Response to Submissions; Department’s Key Issues letter; and Preferred Development.

SSD 17_8766 - SSD DA

Nepean Hospital and Integrated Ambulatory Services Redevelopment (Stage 1)

1.0 Response to Agency Submissions

VEGETATION

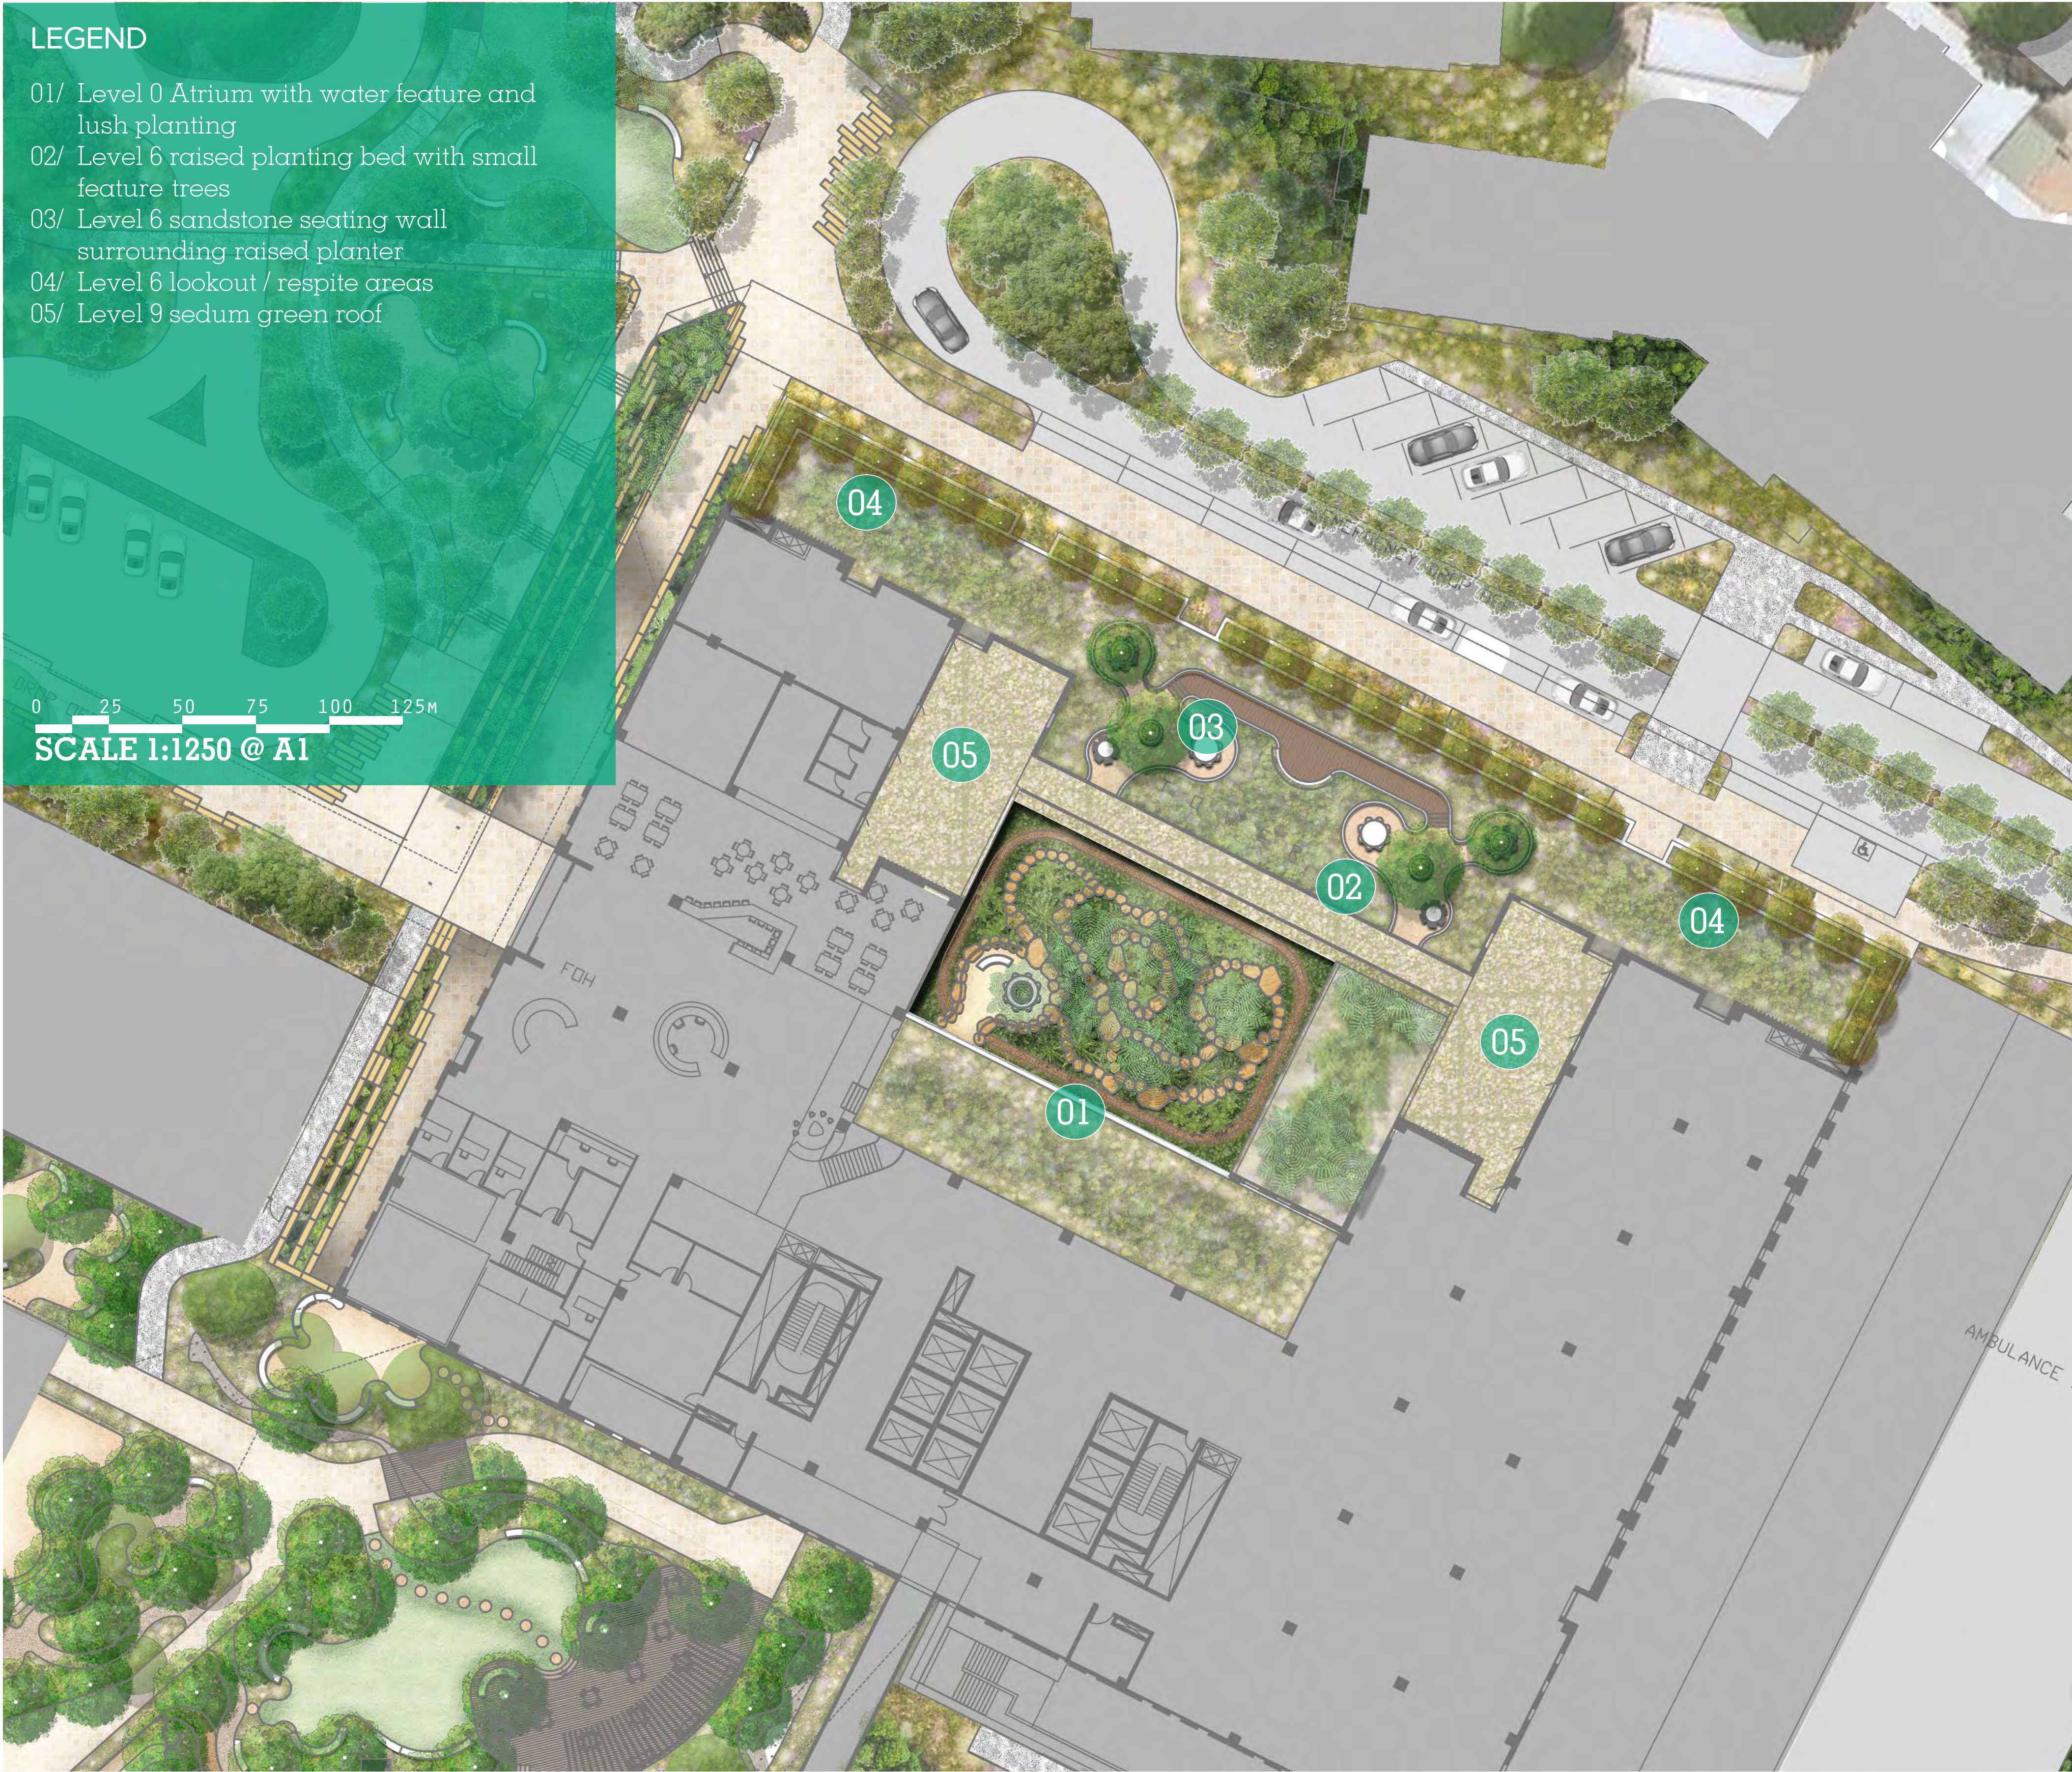
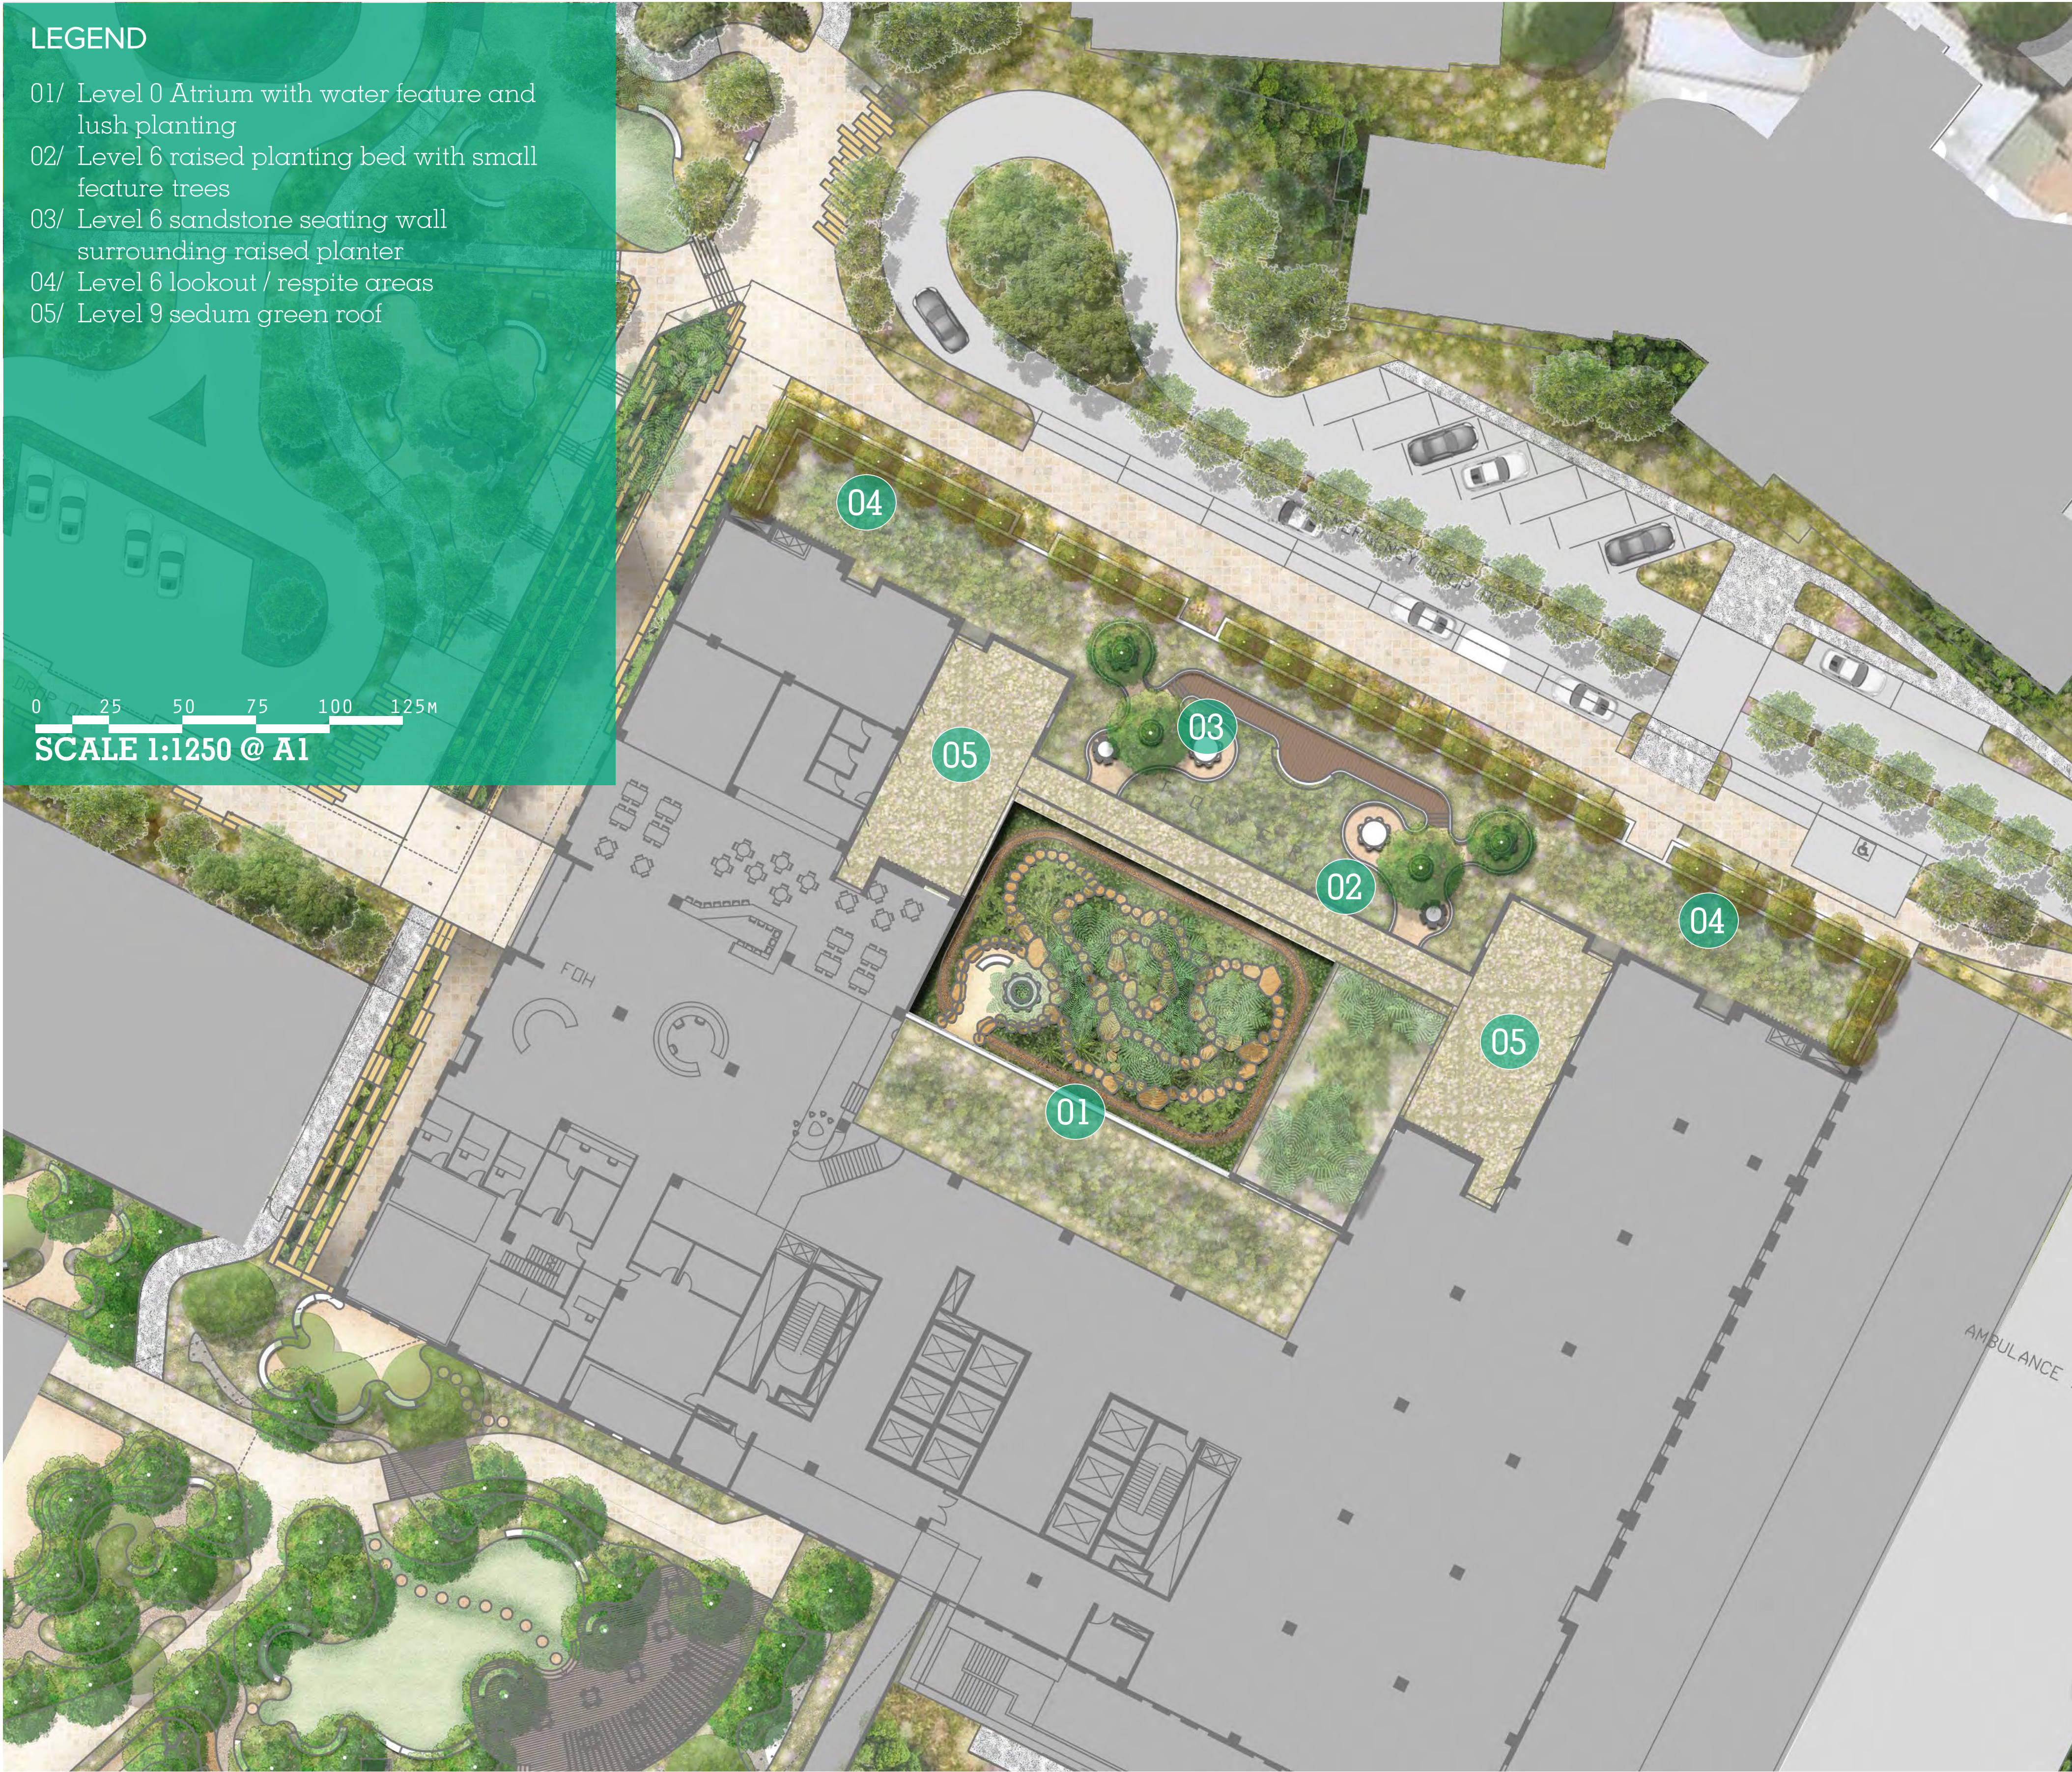
Landscape Design and Landscape Character	
<p>The proposed landscape vision for the site is predicated on a Blue Mountains character theme which is inappropriate given the availability of limited landscaped space and the urbanised nature of the development.</p> <p>The site is not within the Blue Mountains and is located within a health and education precinct which will be surrounded by multi storey residential, commercial and medical developments rather than an expansive bushland setting.</p> <p>This same concern was raised with the Hospital in the design of the landscape treatment surrounding the Car Park Structure, recently approved through the Sydney Western City Planning Panel.</p> <p>The landscape theme and planting design should be revised to reflect the urban landscape setting in which the site sits, with</p>	<p>Arcadia, the project’s landscape architect, has provided a written response to this matter – see Appendix C.</p> <p>In the response, Arcadia advises, amongst other things that, the design is not predicated on a Blue Mountains character theme. Rather, the design acknowledges the site’s proximity to the Blue Mountains, the Nepean River and the lakes system, which from the elevated vantage points (that the new towers will provide) will be visually prominent and inherently contextual. The acknowledgement of the contextual connection to the Blue Mountains is just</p>

one part of the design strategy. The landscape condition that the proposed built forms create closely replicates some of the microclimatic growing conditions of the Blue Mountains.

The existing site cannot be considered to be an urban landscape setting from which to start afresh. Unlike many other hospital sites across Sydney, the Nepean Hospital Campus has an existing landscape character that reflects its unique location through both landform and tree planting.

The retention of locally indigenous mature trees has been a key principle throughout design development. This helps to maintain some of the local Cumberland Plain Woodland landscape character while mitigating the physical and visual bulk and scale of the substantial built form elements proposed.

The species and their locations have been considered and are aligned with the soil landscape and past vegetation patterns. There are also a variety of planting styles that will be employed across the site that are more directly related to the new growing conditions around introduced building elements.

The planting strategy will reduce maintenance of landscape areas – a major consideration of the hospital operations staff during workshops / engagement in the design phases. Endemic / indigenous plants are well suited to site conditions with lower water requirements. They also provide better habitat for local fauna.

Arcadia also acknowledges previous comments from Council regarding the Hospital Car Park site and will consider the plant spacings and species selection when developing the more detailed schematic plans for the softworks.
